Online Comment

Application	H14-0222-24
Location	75 Church Street Pinchbeck Spalding PE11 3YA
Proposal	External alterations including new frontage, the installation of shutters, and installation of condensing units

Name	Greg Watkinson
Address	Conservation Officer

Proposed GF Plan & Elevations

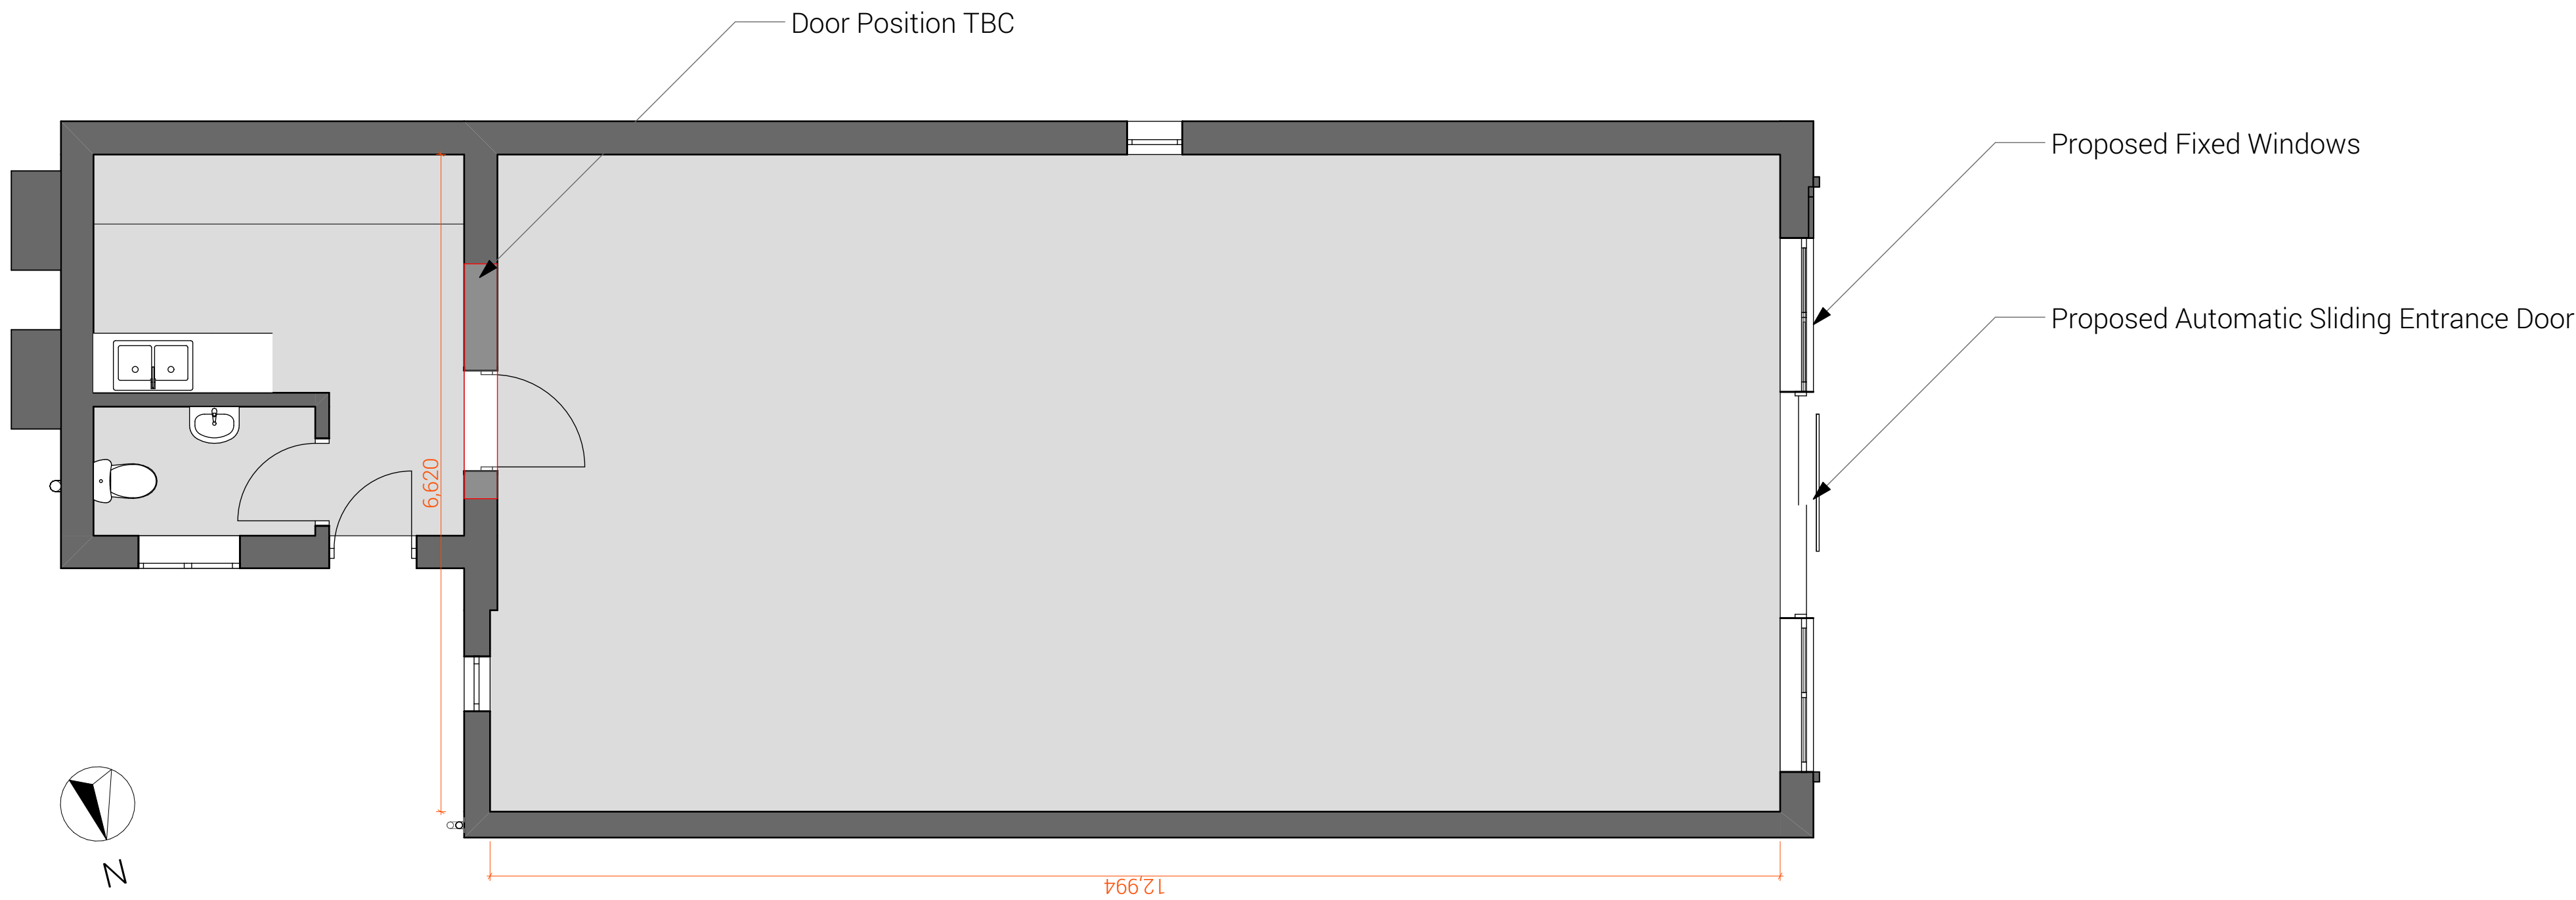
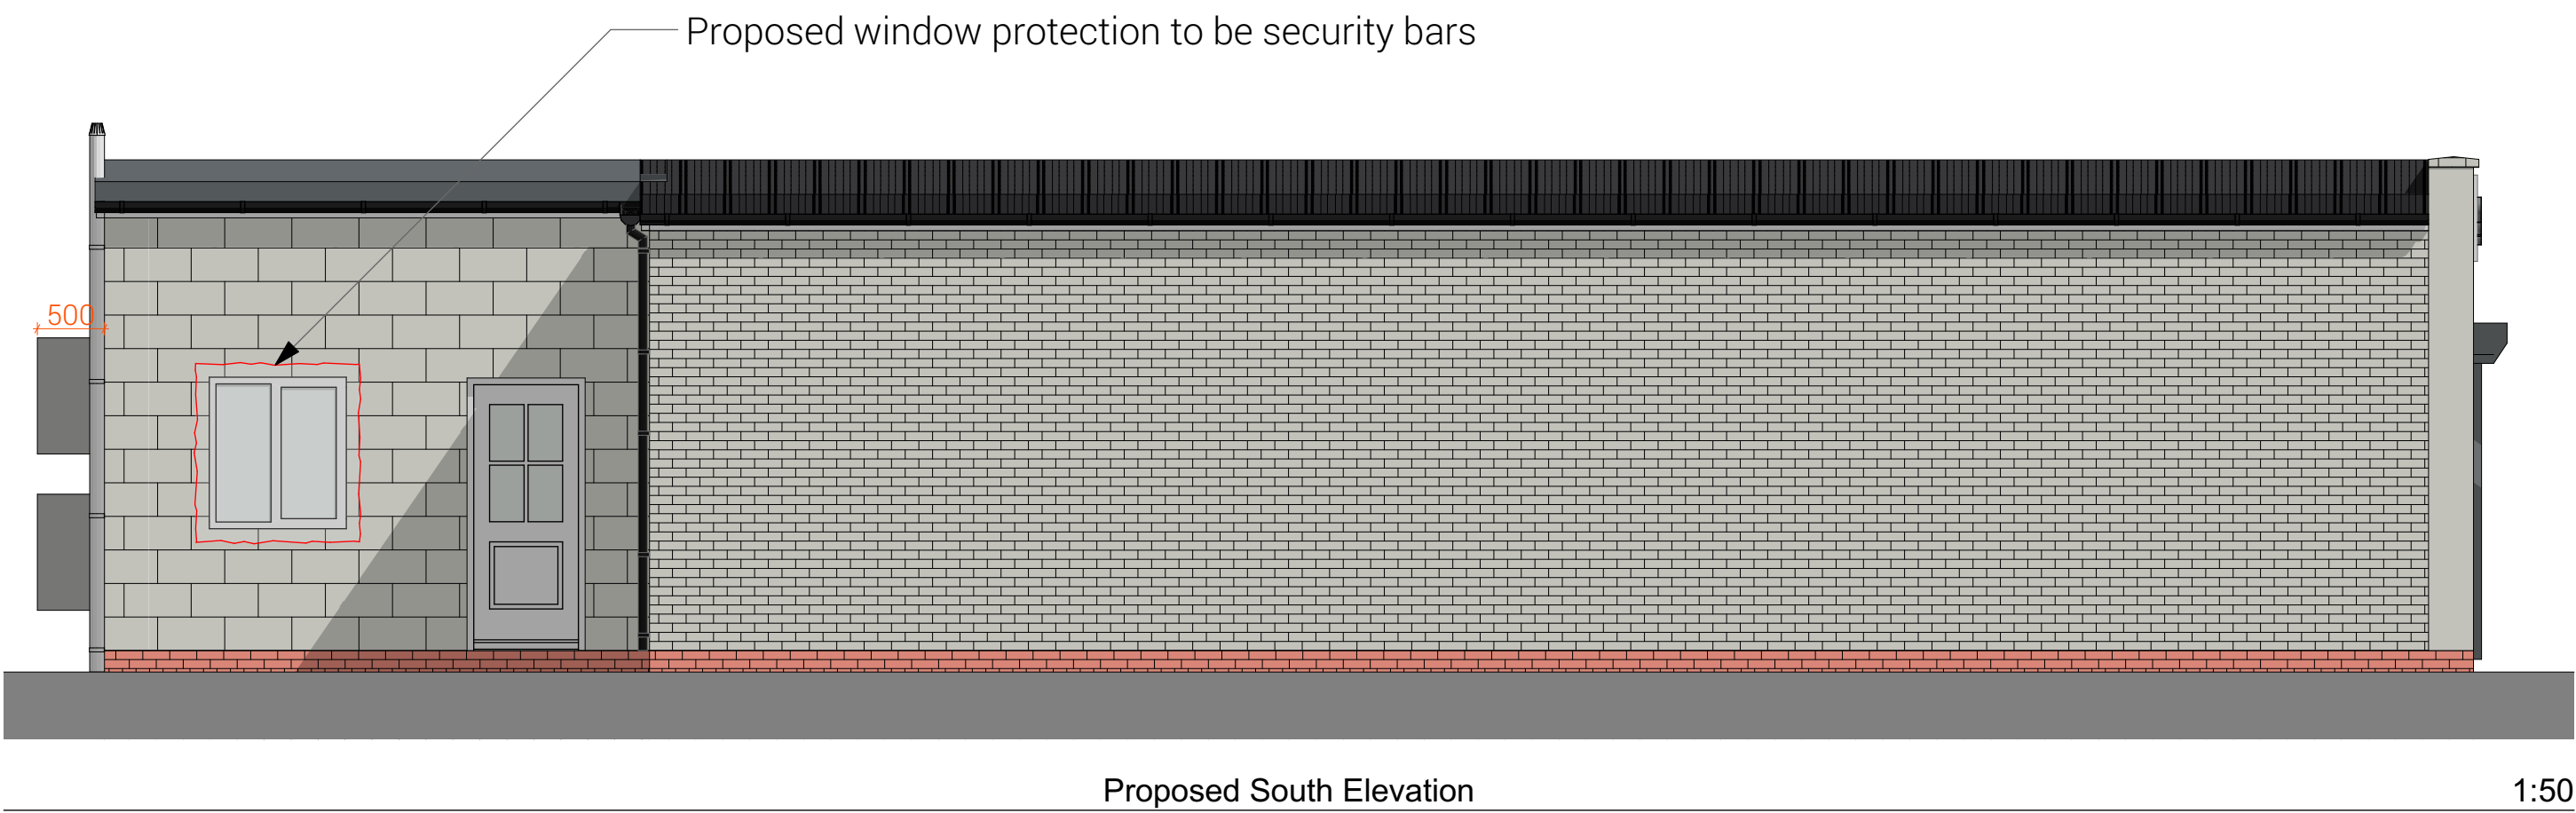
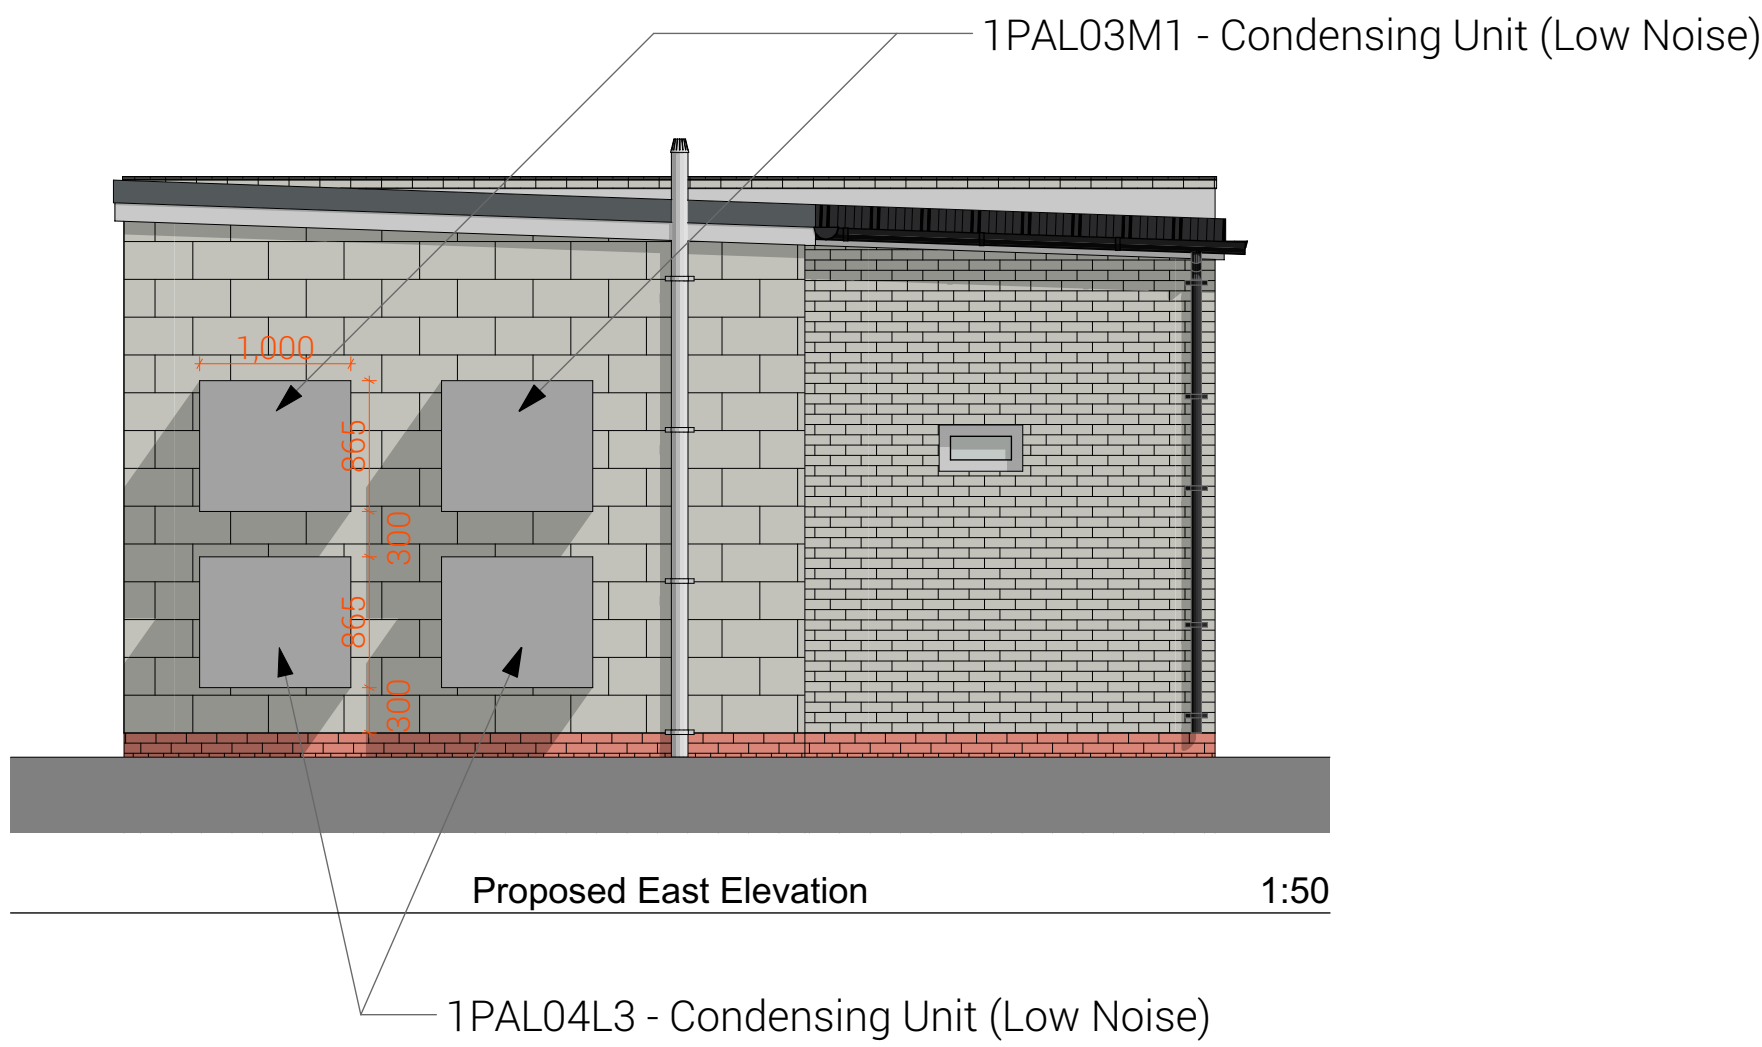
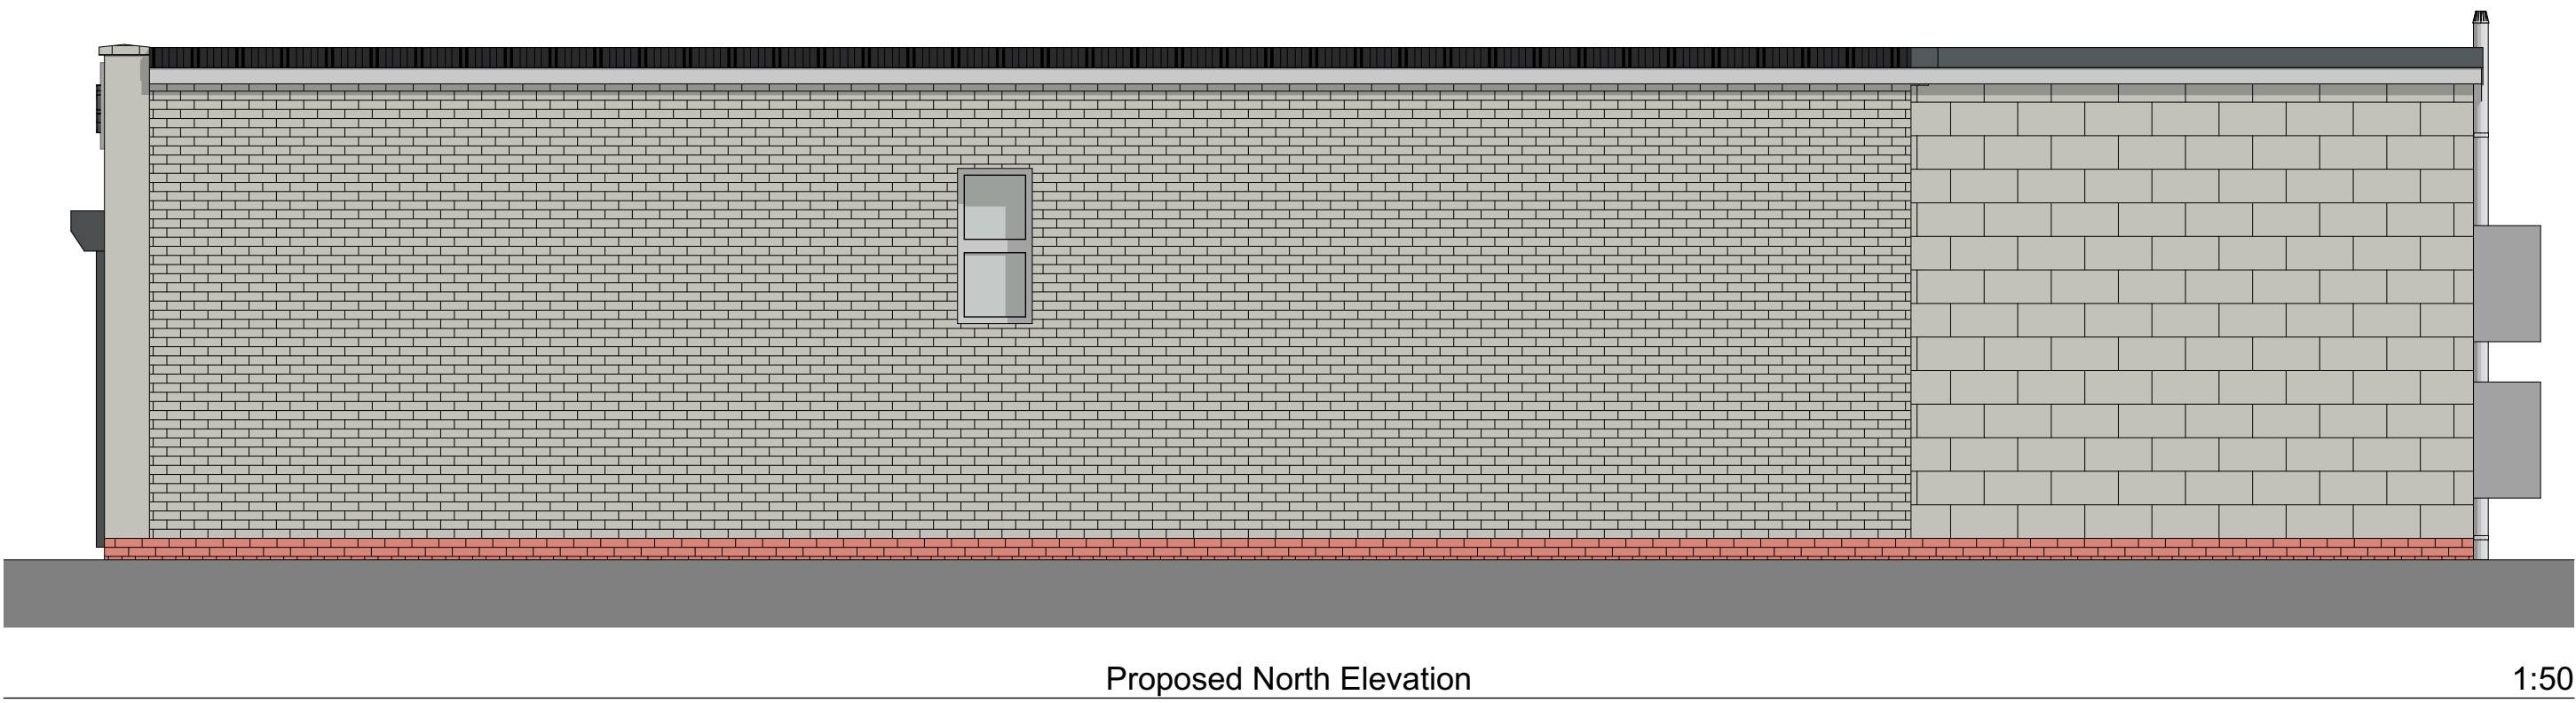
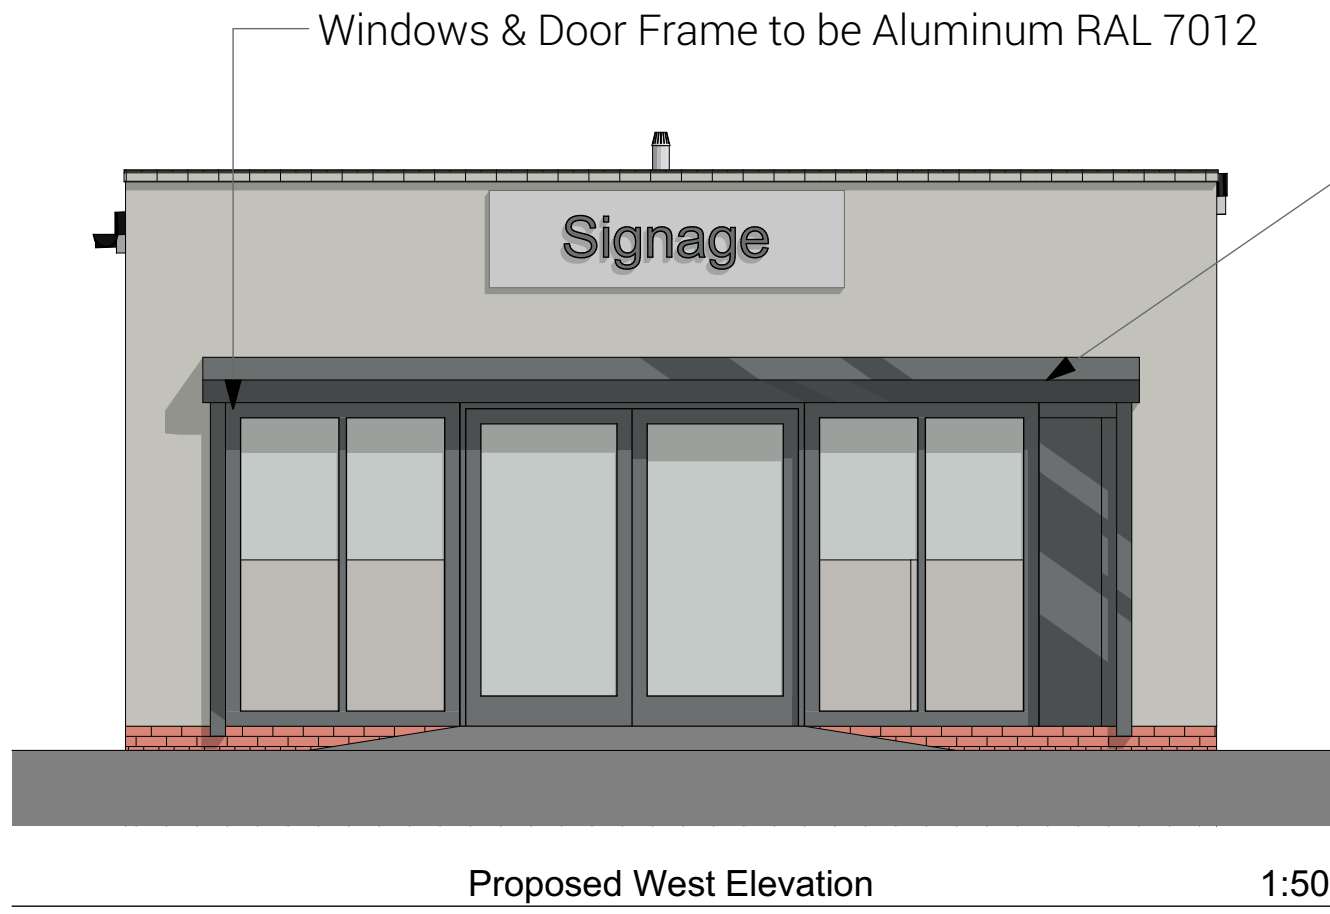
However, I do object to the proposed installation of an external roller shutter system. Such systems are typically considered to be inappropriate to historic environment settings, owing to the harsh and unattractive impact they have upon the street frontage during non-operational hours. I would therefore suggest that to achieve compliance with Policy 29 of the SELLP, the applicant should be required to propose alternative, lower-impact security measures or remove the shutter proposal entirely.
